Planning Application Ref: Was BR/163/16/PL now BR/80/17/PL

Location : Land east of Pumping Station, Highcroft Close, Bognor Regis

Description of works: Construction of 1 No bungalow on a triangle of grass pasture behind the Pumping Station and abutting an Allotment.

Consultant Arboriculturist

PROPOSED GROUND FLOOR PLAN
& SITE BLOCK PLAN.

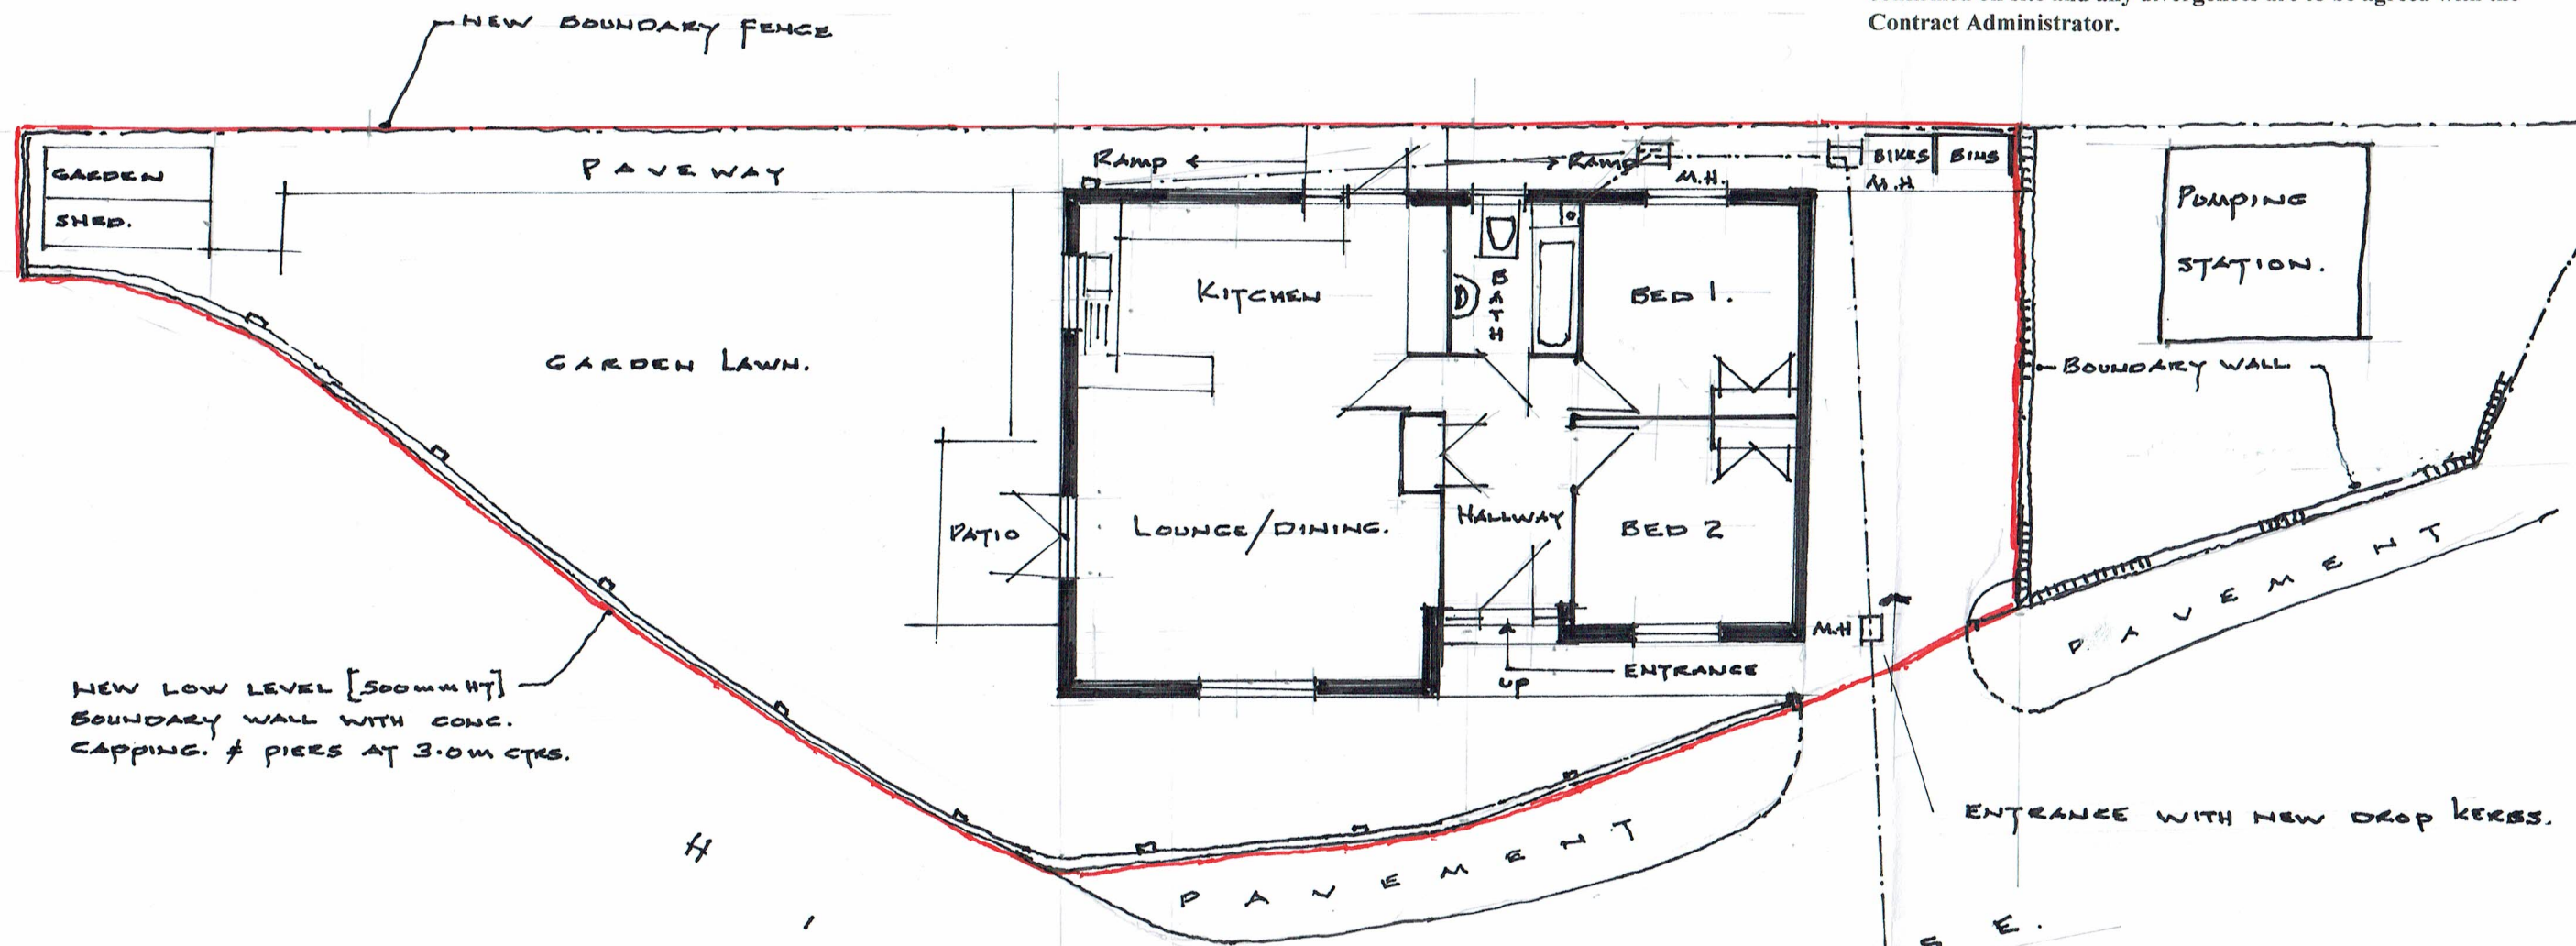
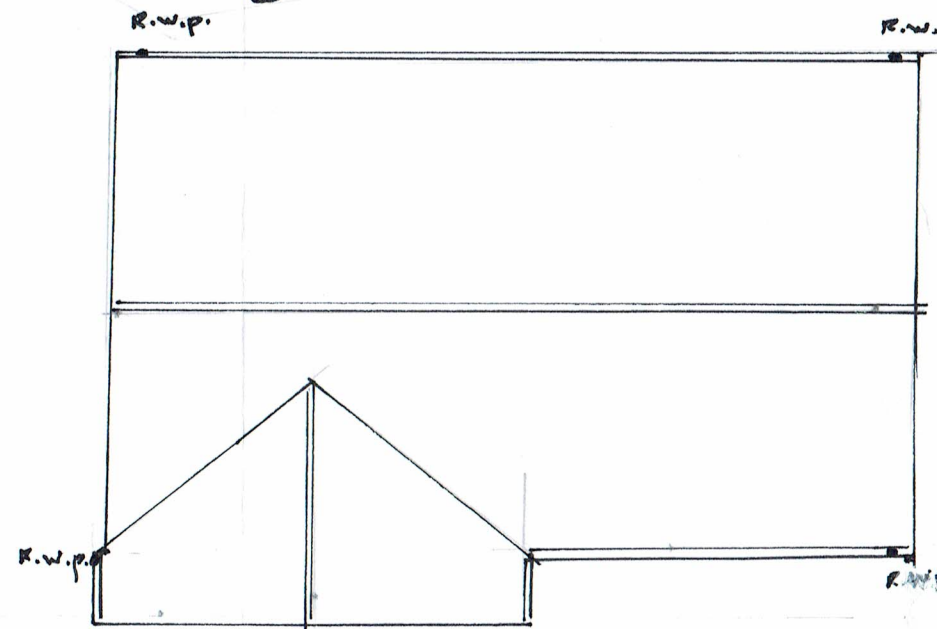
- There are no trees on the Plot itself but there are three trees on the adjacent Allotment land very close to the fenceline.

- There are two Hawthorns and one Elderberry and whilst they are not trees of quality they do exist and are on land that is not under the control of the applicants.
- No mention has been made of their existence or what action is proposed.
- It is possible that by agreement with the Allotment owners they may choose to have the trees removed BUT if they are to stay then the bungalow will be within their RPA and thus an Arb Impact Assessment and Method Statement report and Tree Protection Plan will be needed to explain what mitigation measures will be applied to ensure that these trees are retained in good order without detriment to their health and vitality.
- There are no Arboricultural reports listed on the website so I have assumed that none have been prepared and submitted in support of this new application.

- As submitted I raise an **Objection** on tree grounds and would require further information to be submitted regarding the applicants intentions and proposals as regards the off-site trees.
- I sustain my **OBJECTION** on tree grounds and would still require further information to be submitted regarding the applicants intentions and proposals as regards the off-site trees.
